MERITON APARTMENTS

131-138 KILLEATON STREET, ST IVES

ACCESSIBILITY REVIEW

30th June 2010

ADAPTABLE UNITS

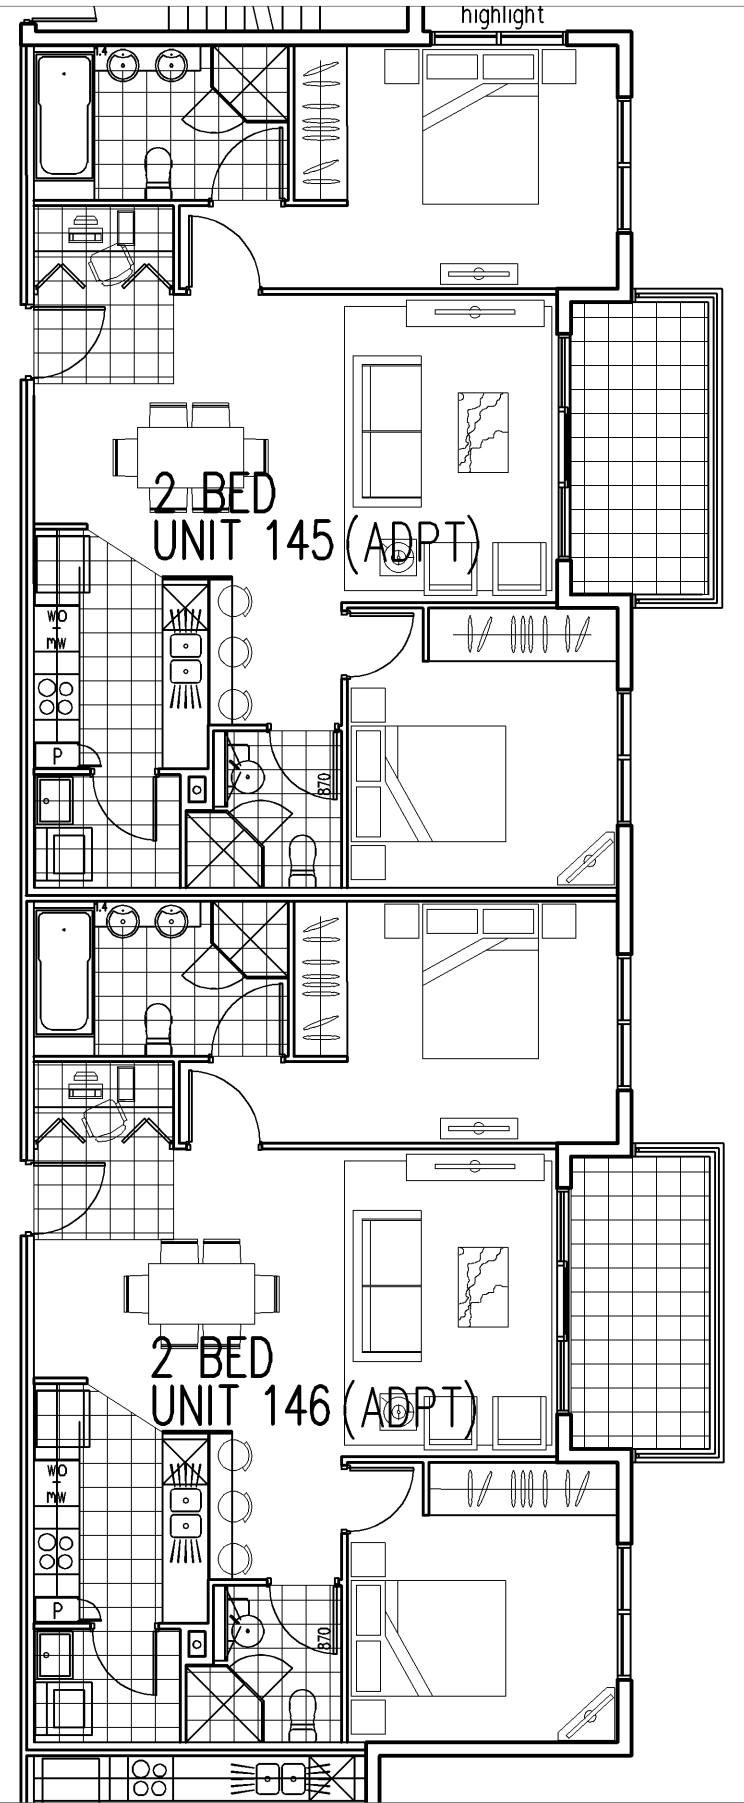
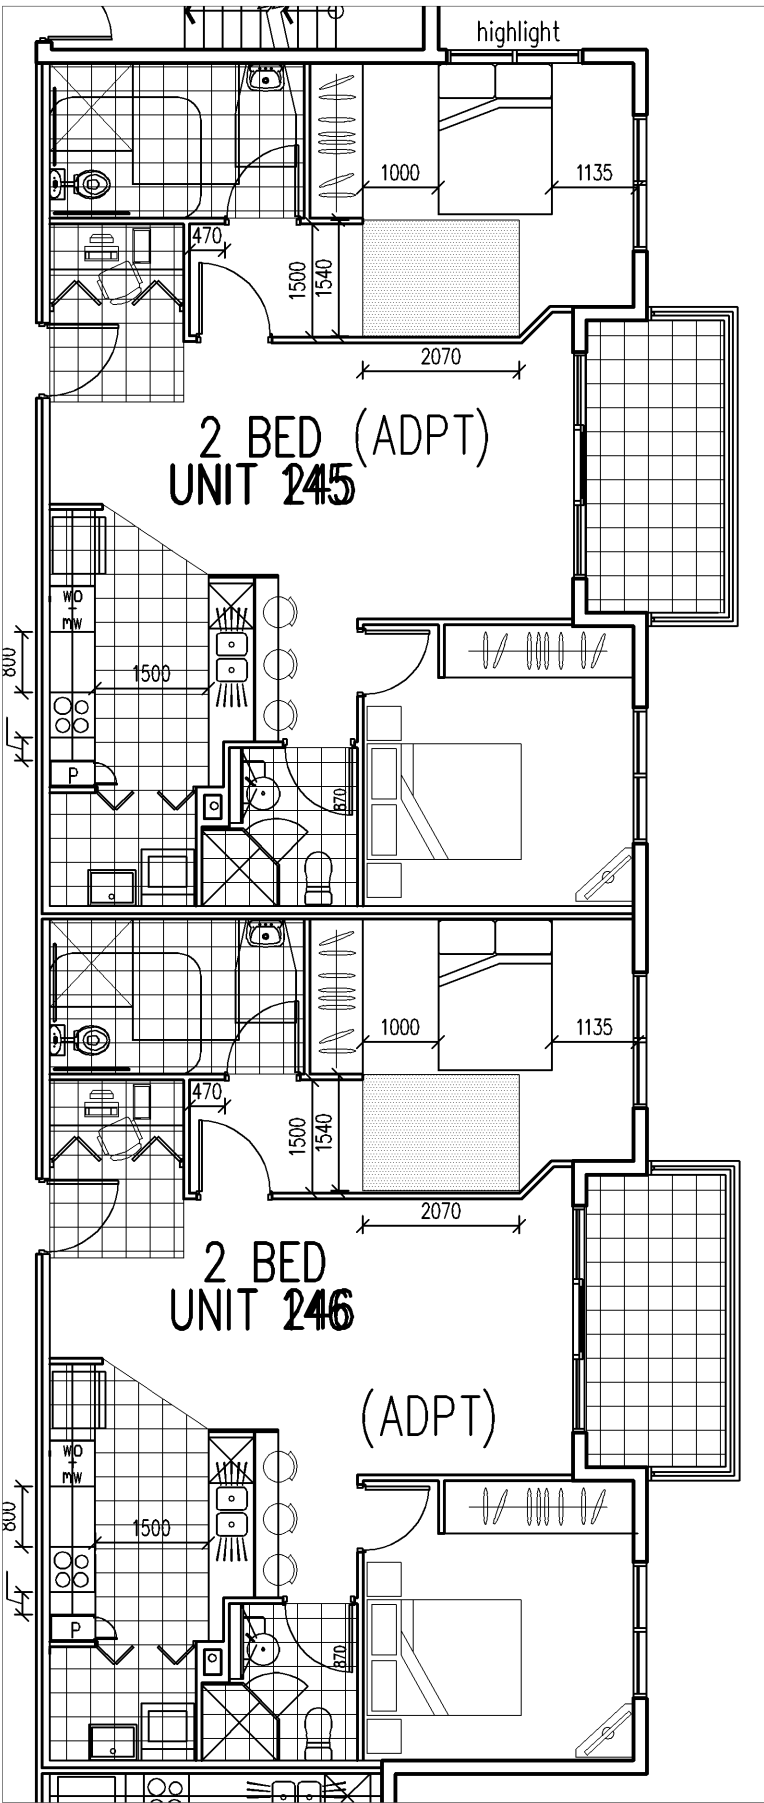
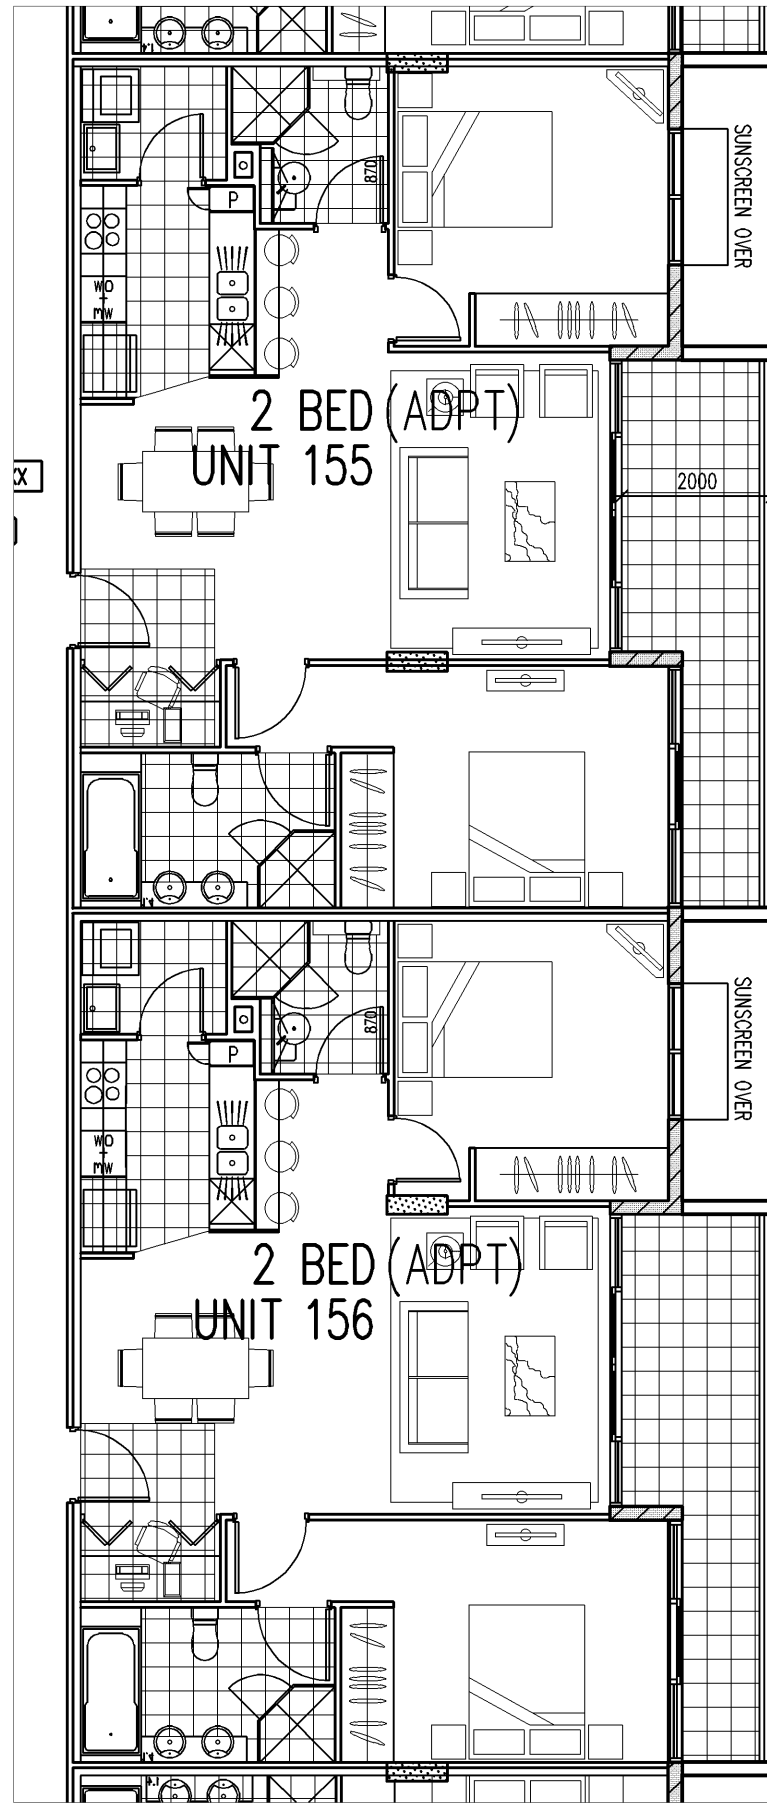
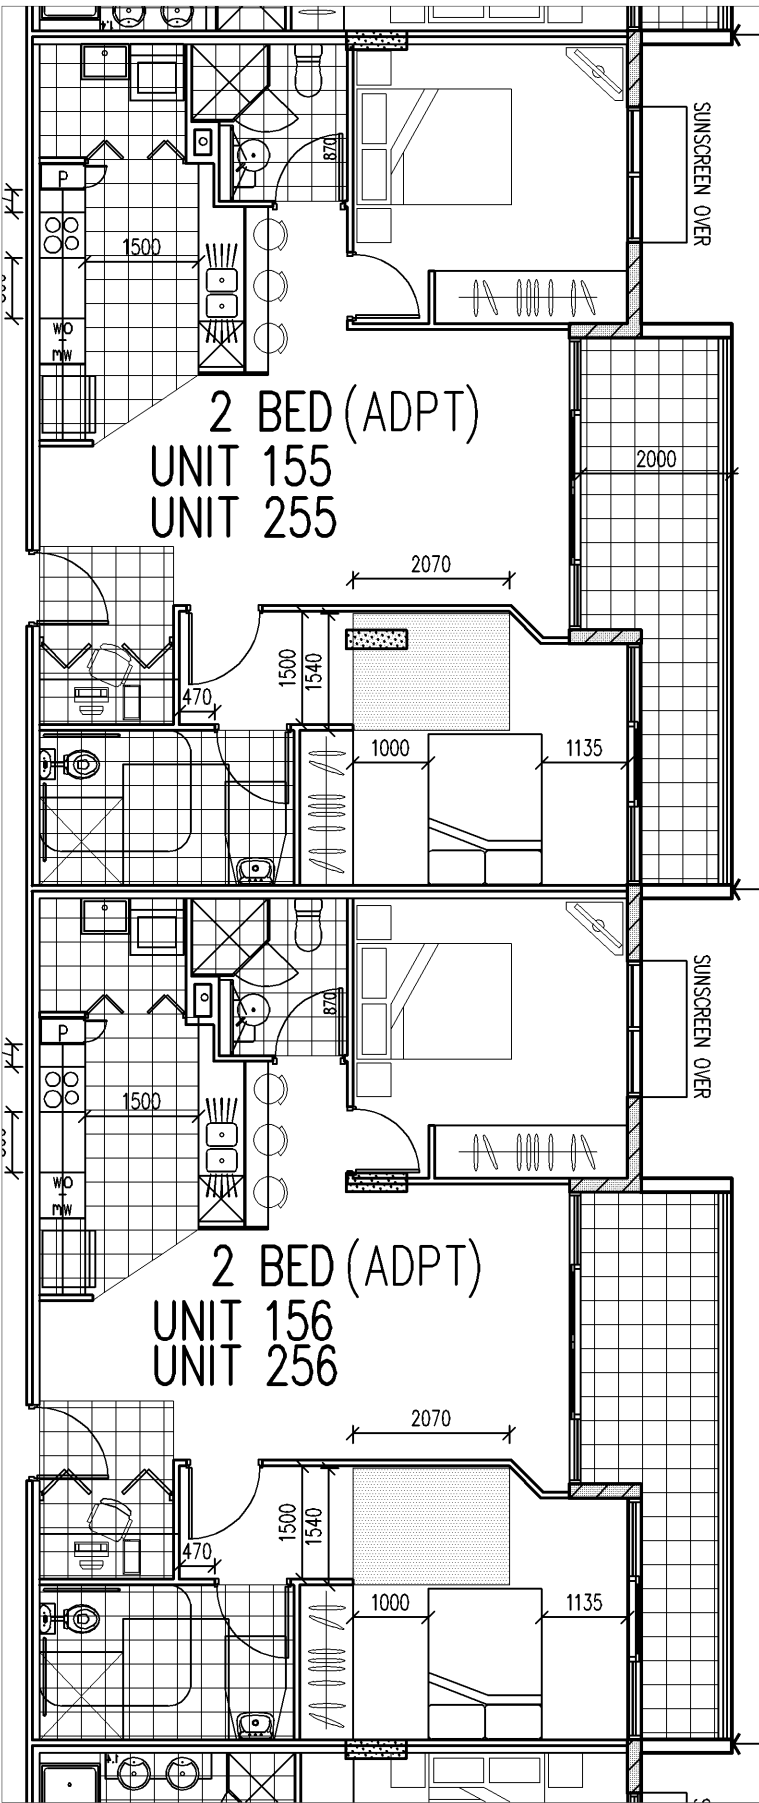
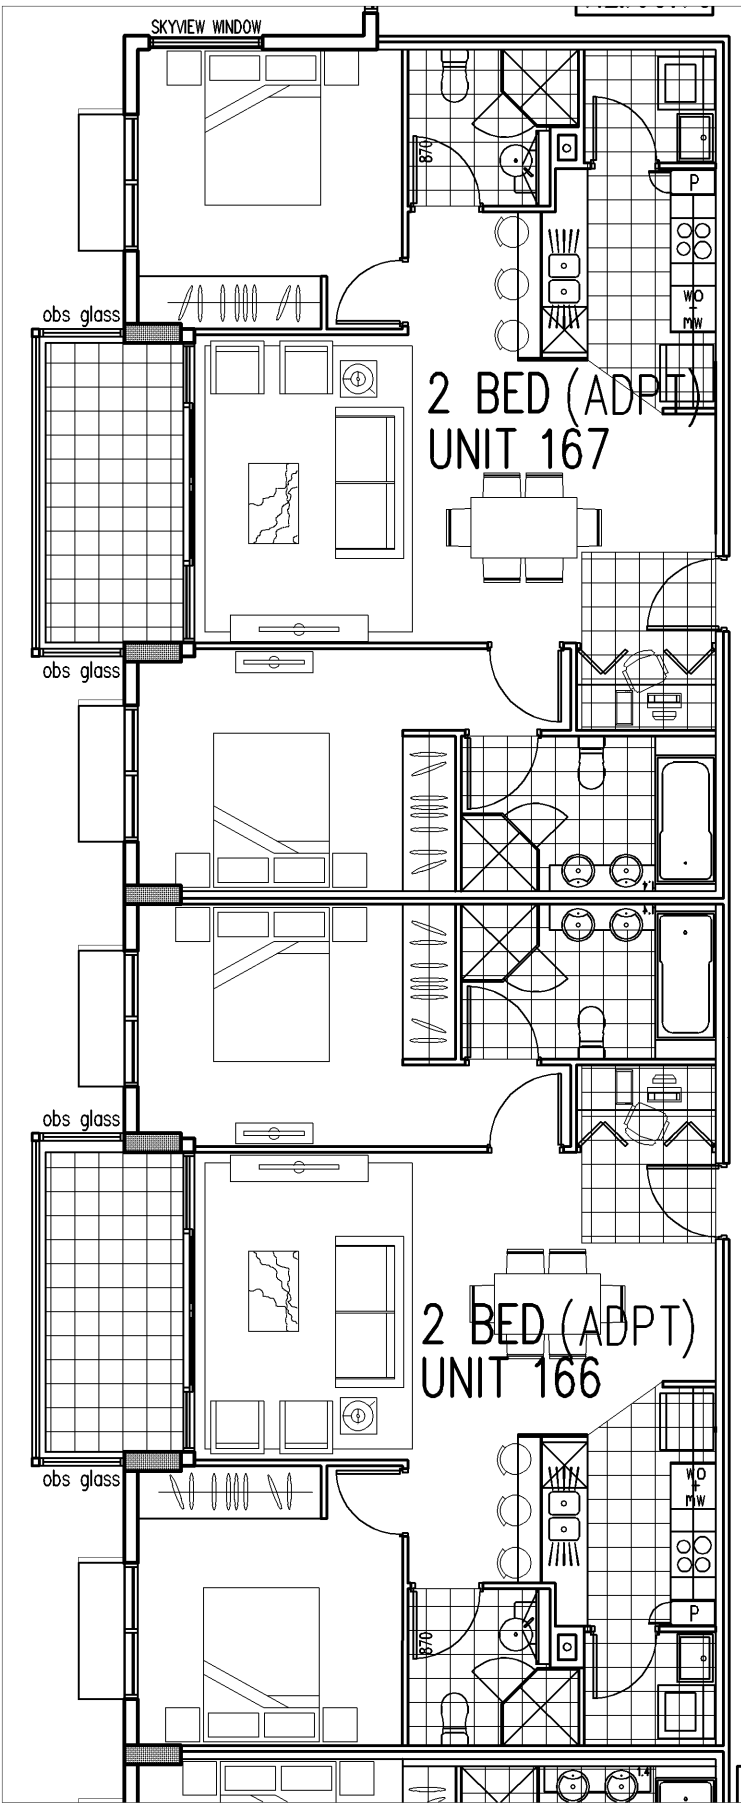
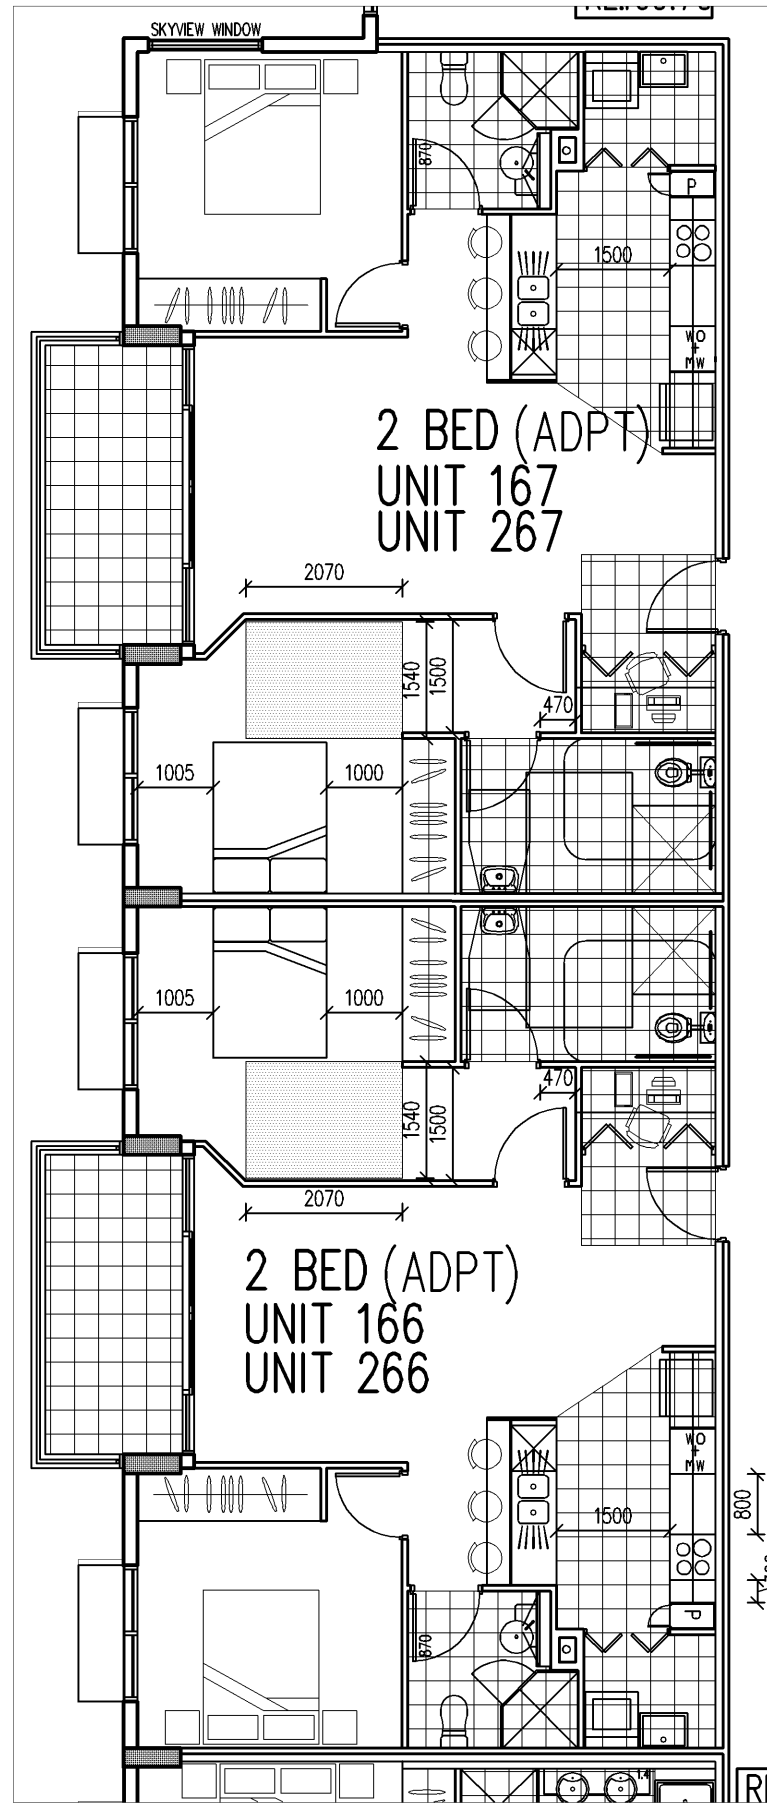
The following recommendations have been made in relation to the typical 2 bed adaptable layout of units 101 and 201 provided.

- i) The bedroom requires internal dimensions of 3600mm x 3600mm, outside the robe area. This will ensure a minimum 1000mm clear width is provided alongside the bed
- ii) Provide separate cook top and wall mounted oven with 800mm long bench between each. Provide a work bench space (800mm in length) adjacent to refrigerator, cook top, wall oven and sink.
- iii) The laundry area (found within the master bathroom) is to have a circulation area in front of the laundry appliances of 1550mm in diameter
